From: Laura Gibbons
Sent: 05 July 2019 11:31
To: Maria Tomalova <Maria.Tomalova@arun.gov.uk>
Cc: Chris Slade [REDACTED]
Subject: RE: C1214 Soakaway Test Report.pdf LEC Airfield BE/9/19/PL Bersted

Re: BE/9/19/PL LEC Airfield Bersted, Soakaway test report attached

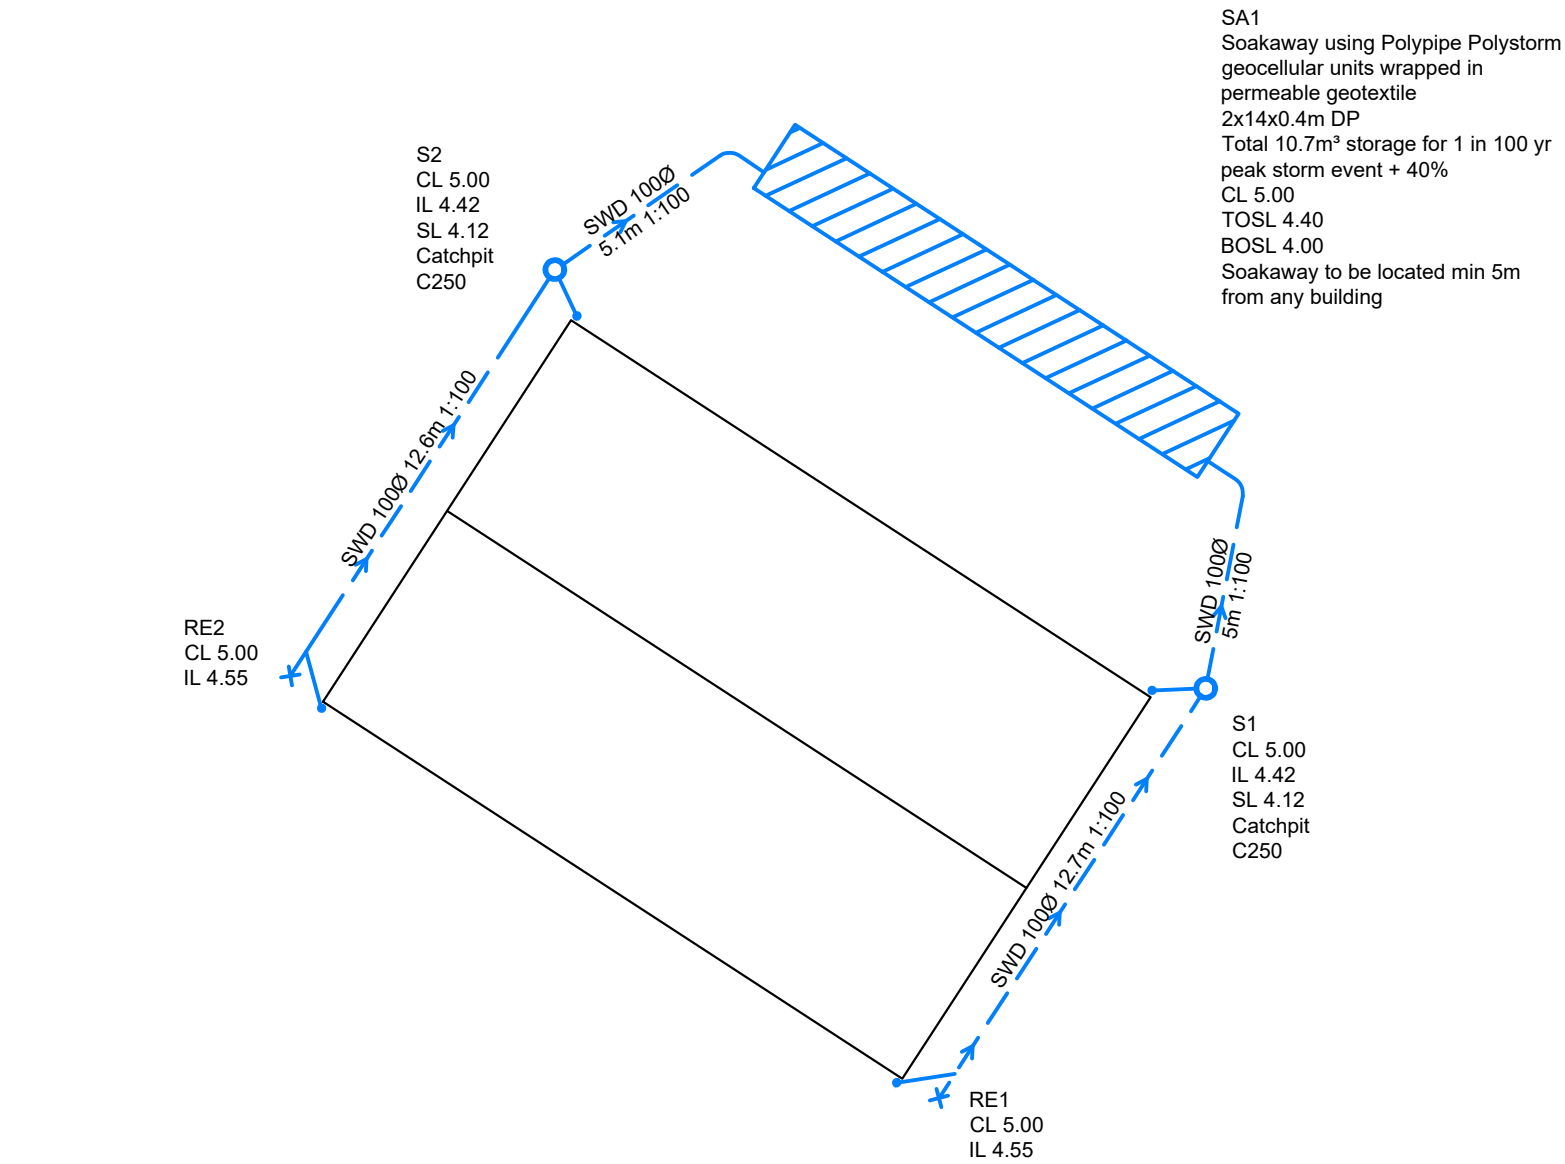
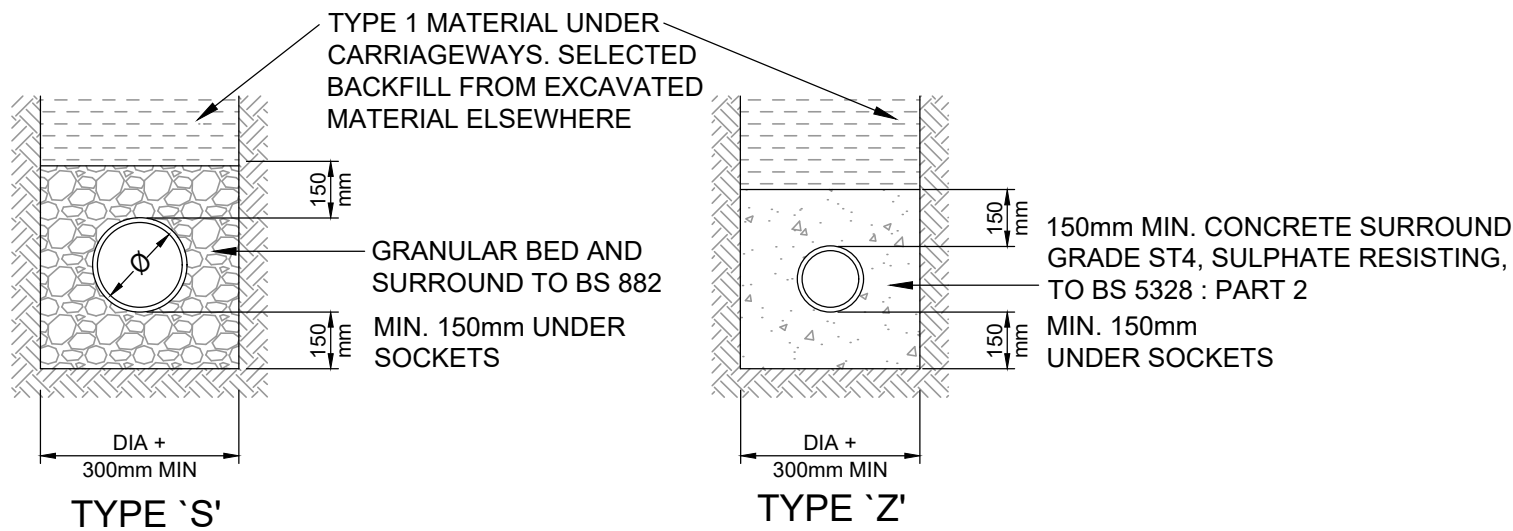
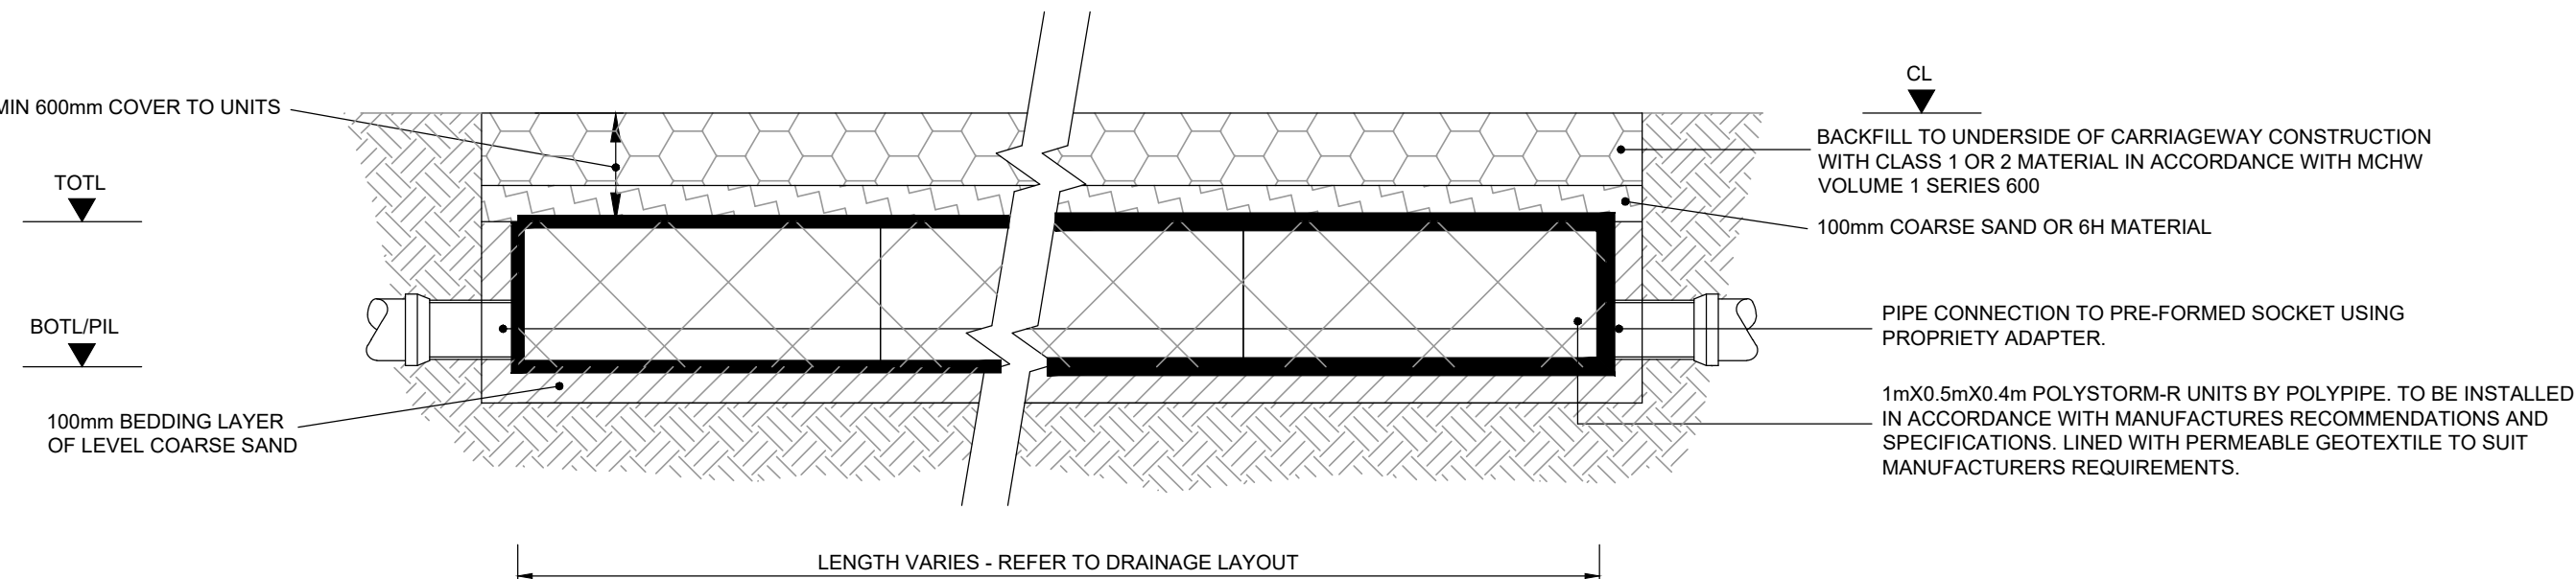
A soakaway needs to be designed based on these rates and using factors of safety as detailed within our checklist (attached for ease of reference). If the details outline within the checklist are submitted prior to determination then the conditions can be removed. Please note this approach is only being taken due to the small scale of the proposals and its location.

I am happy with the supplied documents. Therefore, I remove my request for a condition. If the application is to be approved please reference C1214-100-Drainage Layout in the list of approved plans.

Half Drain down: Structure confirmed as not failing to discharge half the volume within 1440 minutes FOR THE 1 IN 100 YEAR STORM + 40%

Lowest base level of infiltration structure: 1mbgl
